Current Zoning: B-1 (neighborhood business)
Proposed Zoning: MUDD-O (mixed use development, optional) with three-year vested rights

Approximately 0.34 acres located at the southwest intersection of Seigle Avenue and Belmont Avenue, north of Harrill Street.

The petition proposes rezone a lot previously used as an auto car garage to allow the construction of a 9,000-square foot mixed-use building residential and nonresidential uses.

SITE PLAN SCALE 1:20

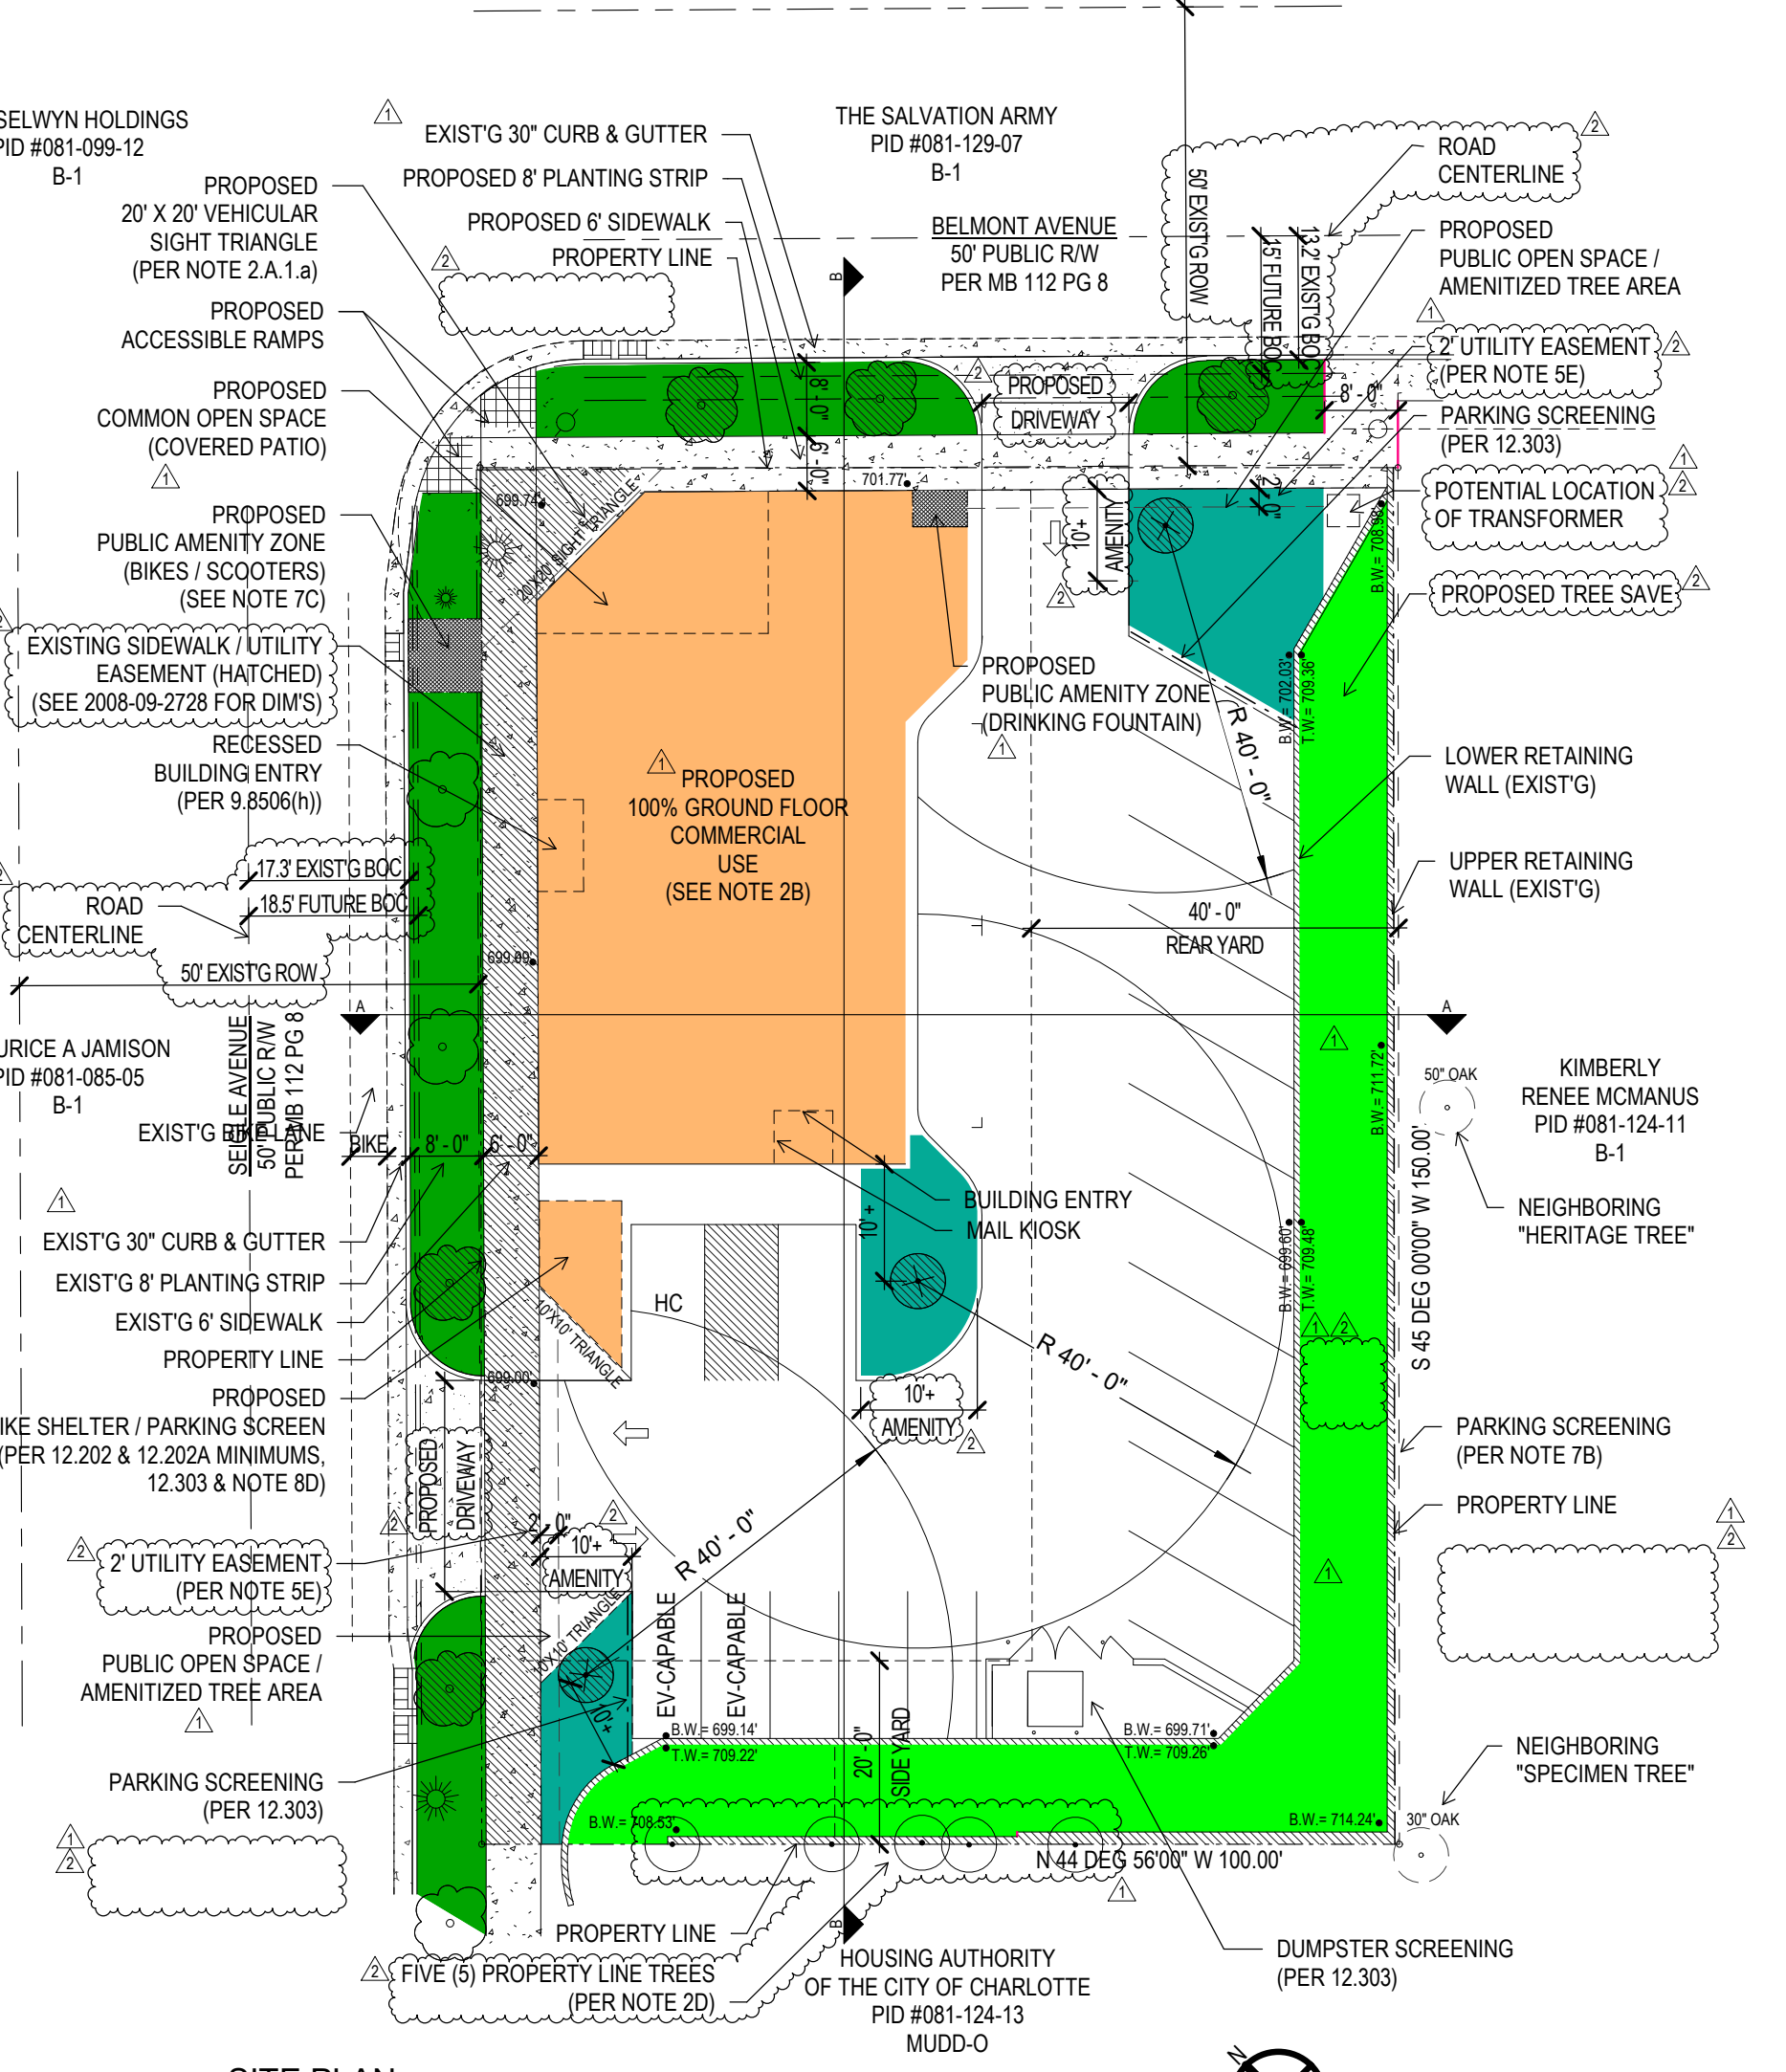
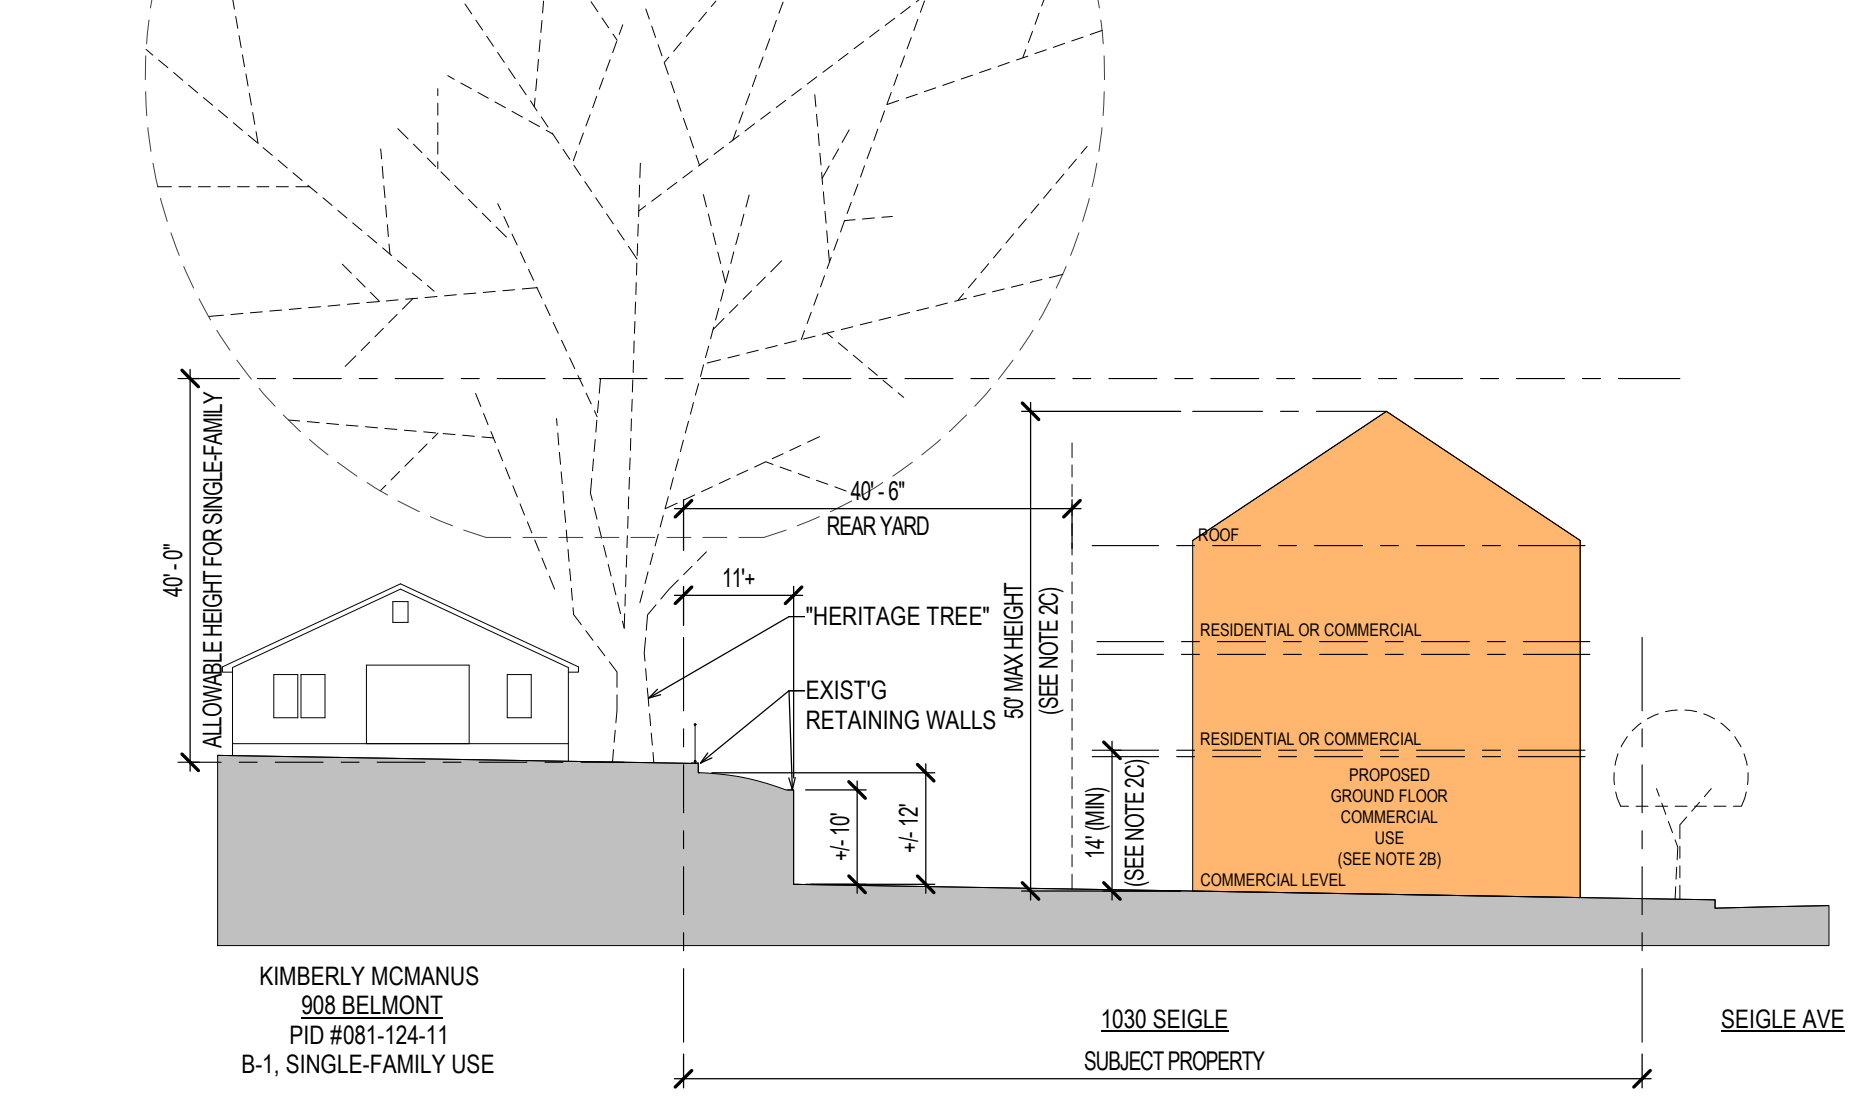
7. Review urban tree requirements. While the 10' no build zone can be counted towards tree save there must still be a minimum of 10' of replanted tree save. (20' total width) Trees cannot be planted within 10' of a structure/retaining wall. Utilities such as transformers are not permitted within trees save or amenitized tree save. **Petitioner response:** Petitioner has reconfigured preliminary off-street parking layout to accommodate 10' distance & 10' width requirements. Potential transformer locations have been moved outside of amenitized tree save (See Site Plan on RZP-01, Rev 2). **Update:** Per discussion, the best option for tree save at this point will be provided per the ordinance and removed "potential tree save" designation for areas that we not sure would even qualify as tree save and review that during development plan review.

8. Trees outside of the property line cannot count towards any requirements. Trees must be completely on the property to count towards requirements. **Petitioner Response:** Petitioner commits to protecting the five "property line trees" on southern property line. (See Note 2D, RZP-01 Site Plan, Rev 2). Petitioner is open to amending the wording of this Optional Provision to suit Urban Forestry, if desired. Note: as provided to Henry Kunzig via 4-17-23 email, center measurement of 12" oak is completely on property at dbh. Updated Tree Survey uploaded to ACCELA. Petitioner is willing to reduce protection to just that tree, if desired. **Update:** While trees on the property line can be protected, trees not completely located on the property cannot be counted towards meeting tree save requirements.
